From: White Horses B and B [REDACTED]
Sent: 07 December 2017 13:16
To: Richard Temple
Subject: Gull Point Development FP/268/17/PL

FP/268/17/PL Comment from White Horses B & B Clyde Rd, Felpham

PROJECT Gull Point Suites - On the Beach
TITLE Typical Sections
SCALE 1 : 100
DATE 20/09/17
DRG NO IBA/480/09
REVISIONS

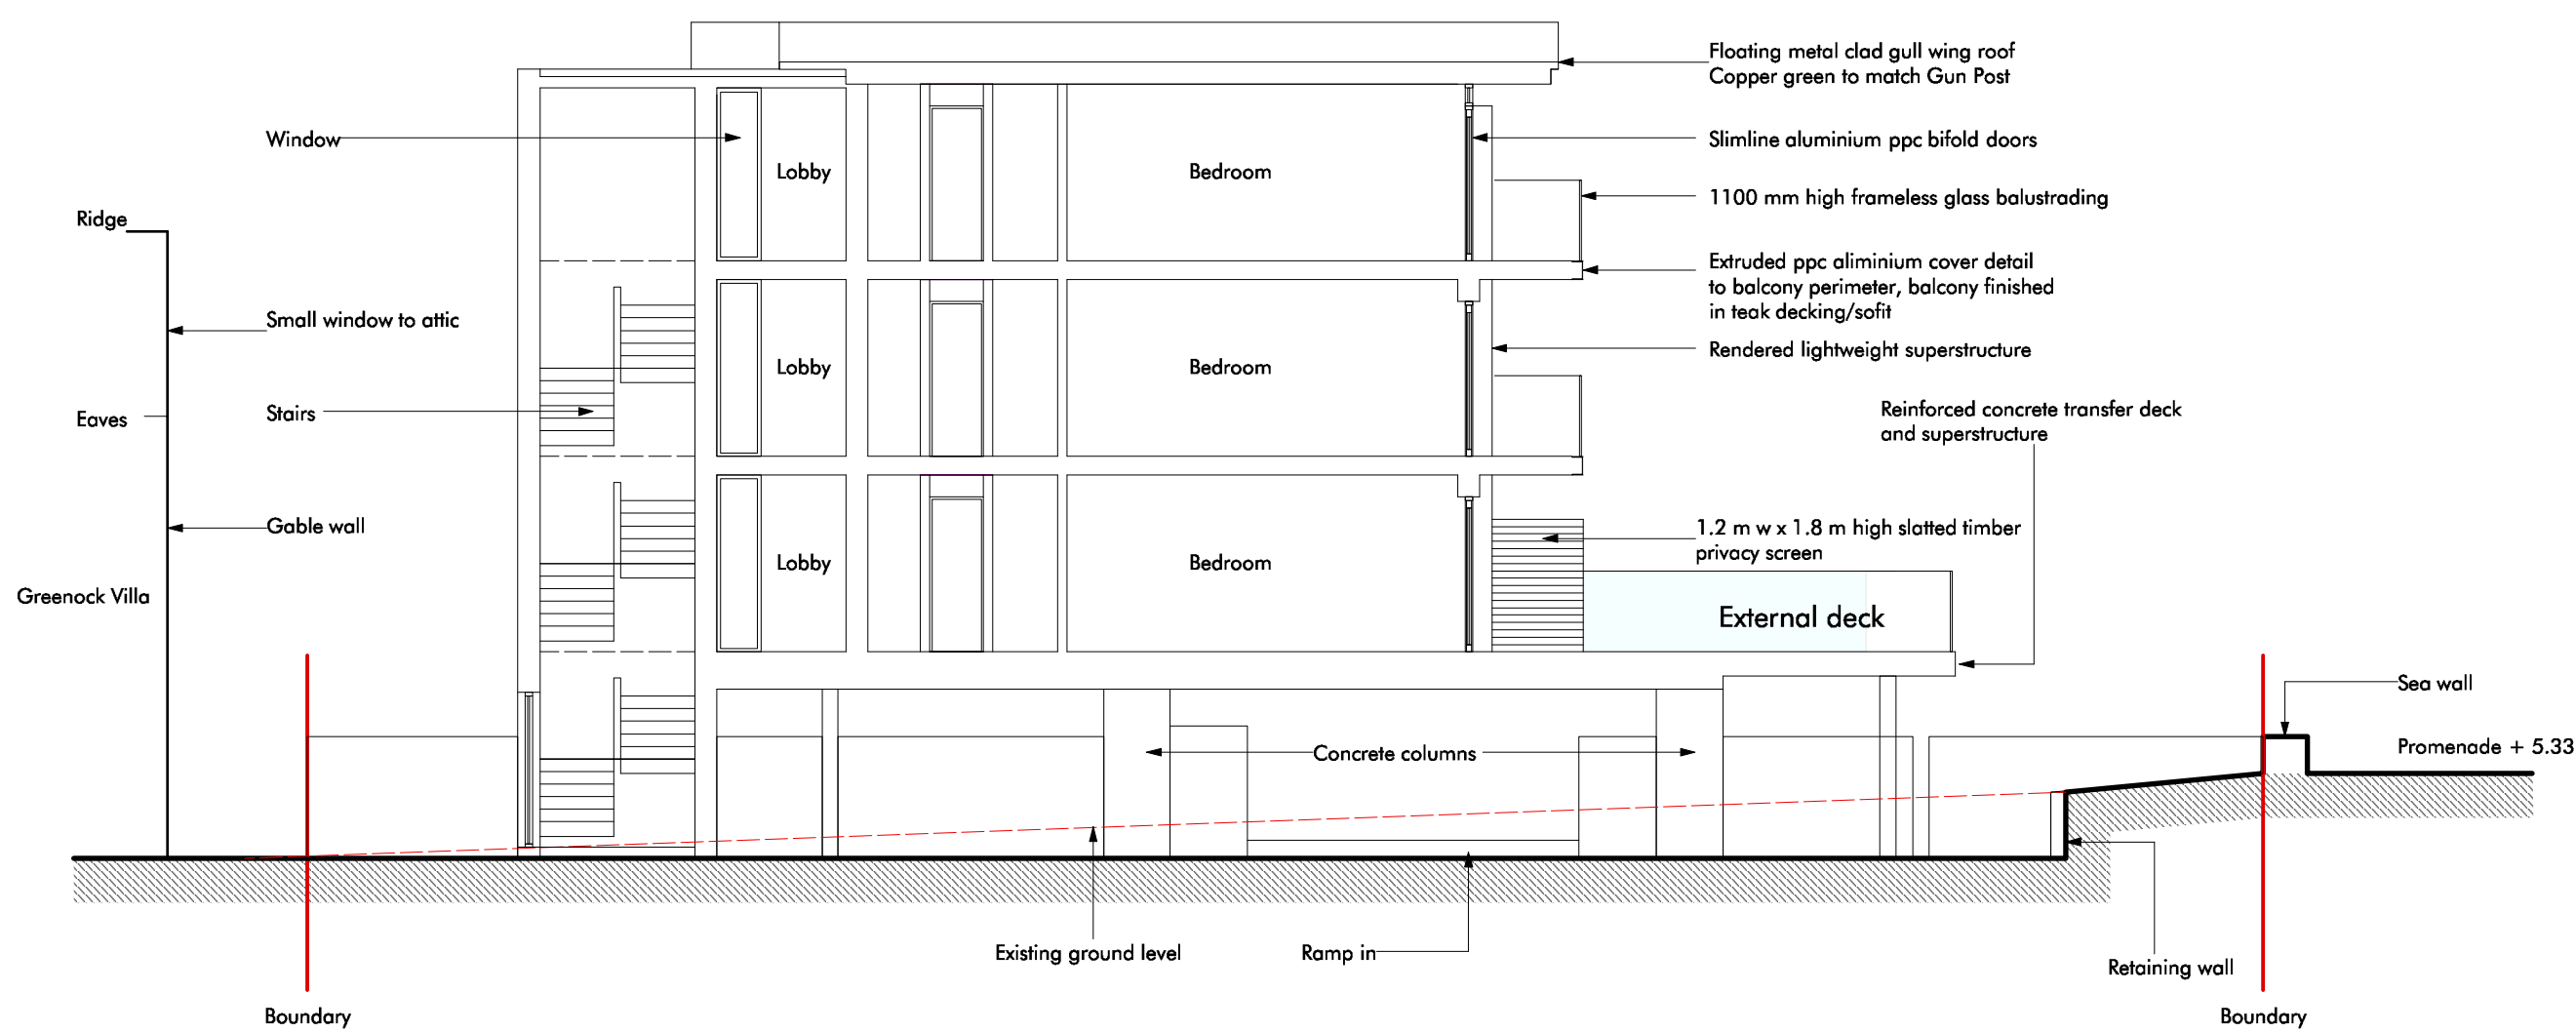
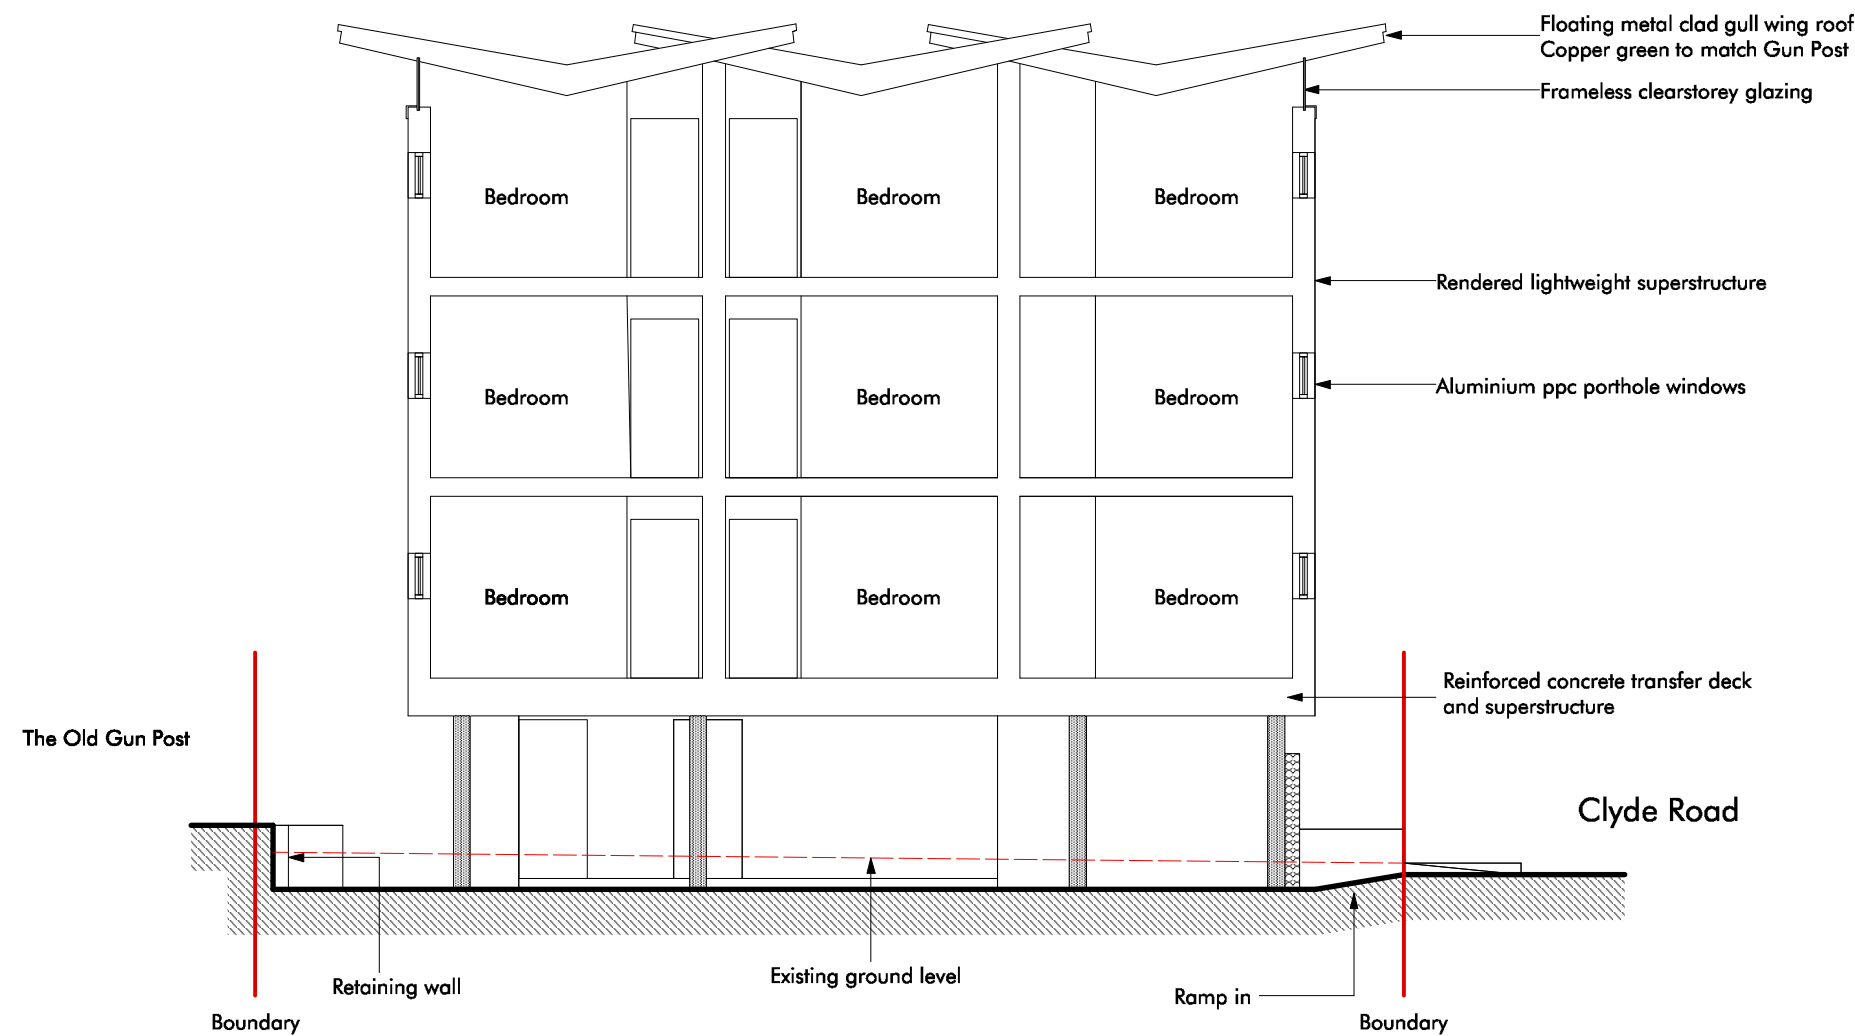
The other is the overall height of The Gull Point development. The Council should ensure that the roofline does not exceed The Gun Post or Coastguards buildings adjacent. It also dwarfs neighbours in Greenock Villa, Abegail and White Horses in a way that is not conducive to surroundings.

The overall height of the development means that we at **White Horses** will lose a high degree of natural light on our front facing guest rooms that the property has enjoyed for over a hundred years and upon which our current small family business depends. The **Rights of Light Act (2014)** does make mention of certain rights in this regard.

Figure 7 Lower Ground Floor Parking Plan

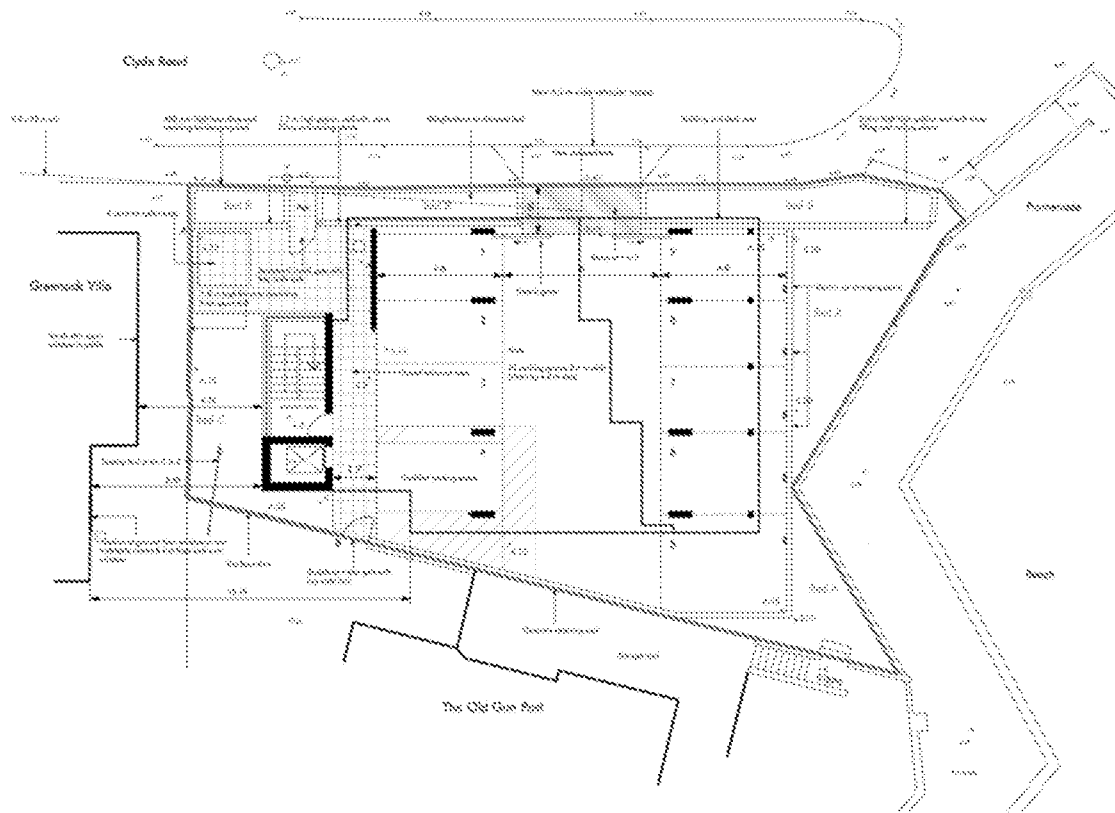
The *visibility splays* (Plan) on vehicle movements in and out of the development do not take account of the fact that for 99% of the time cars will be parked immediately to the left and right of the entranceway. Vehicles exiting will have no vision to left until they have reached the centreline of the road. This will add to the problems of traffic movements in and out of Clyde Road. At any given time traffic can **only** be single file inwards or single file outwards.
